From: Anita Gardner
Sent: 06 December 2018 10:35
To: Planning.Responses
Subject: FW: R/190/18/PL - 2 dwellings, St Marys Close, Rustington

Anita Gardner
Sent: 05 December 2018 17:03
To: Laura Gibbons
Subject: R/190/18/PL - 2 dwellings, St Marys Close, Rustington

Please apply ENGD2B with the requirement for winter groundwater monitoring removed.

In Situ Percolation Test

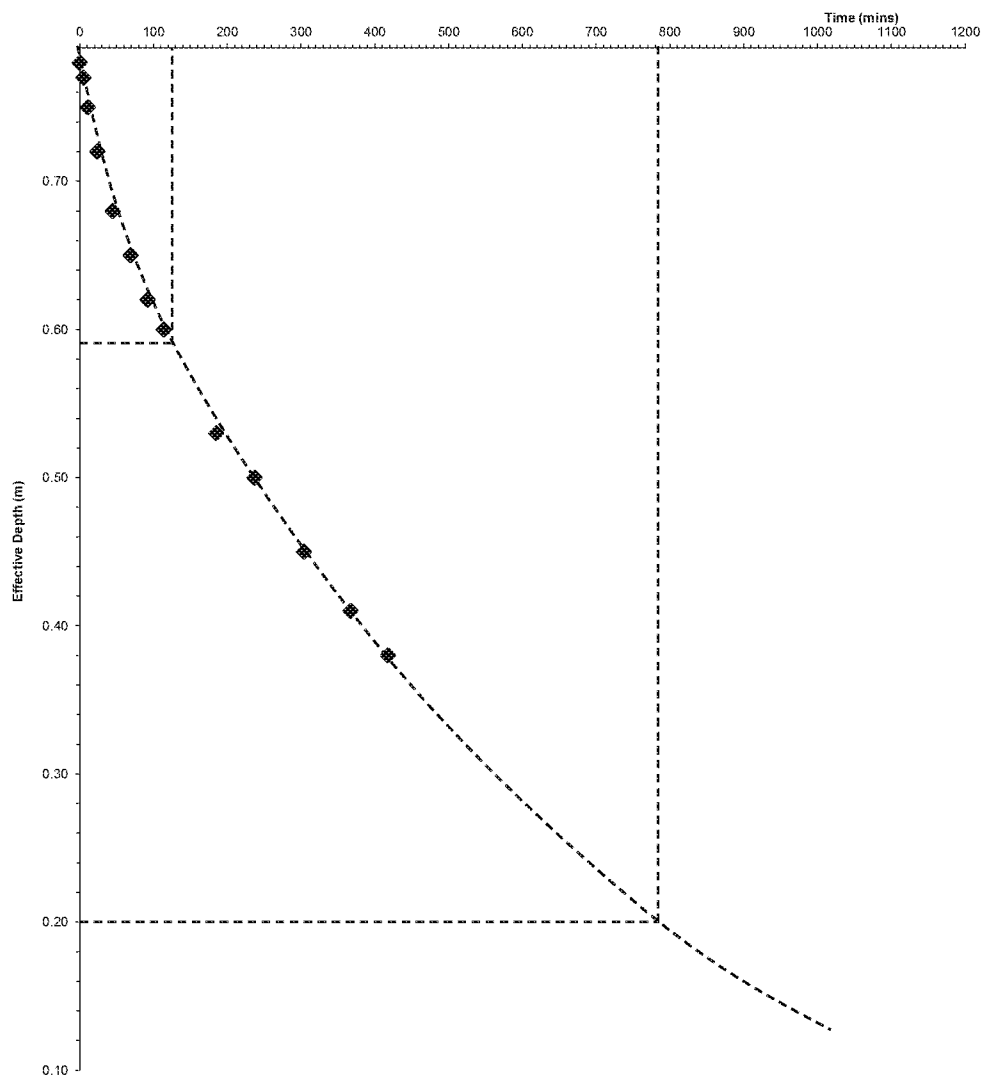
It is noted that winter groundwater monitoring results were supplied with the application. These evidence that groundwater levels were circa 2.2m or deeper in February to April 2018.

One set of infiltration testing results were provided, this test was completed in the summer and at 2.8m depth. We will need to see the results of winter percolation tests that are completed at the designed depths. I.e. shallow tests where permeable paving is proposed. And then tests at a depth less than 2.2m below ground level for the trench soakaways.

To discharge the condition the applicant will need to provide; infiltration test results, calculations evidencing there is sufficient capacity in the system, more detailed layout drawings, and construction detail drawings.
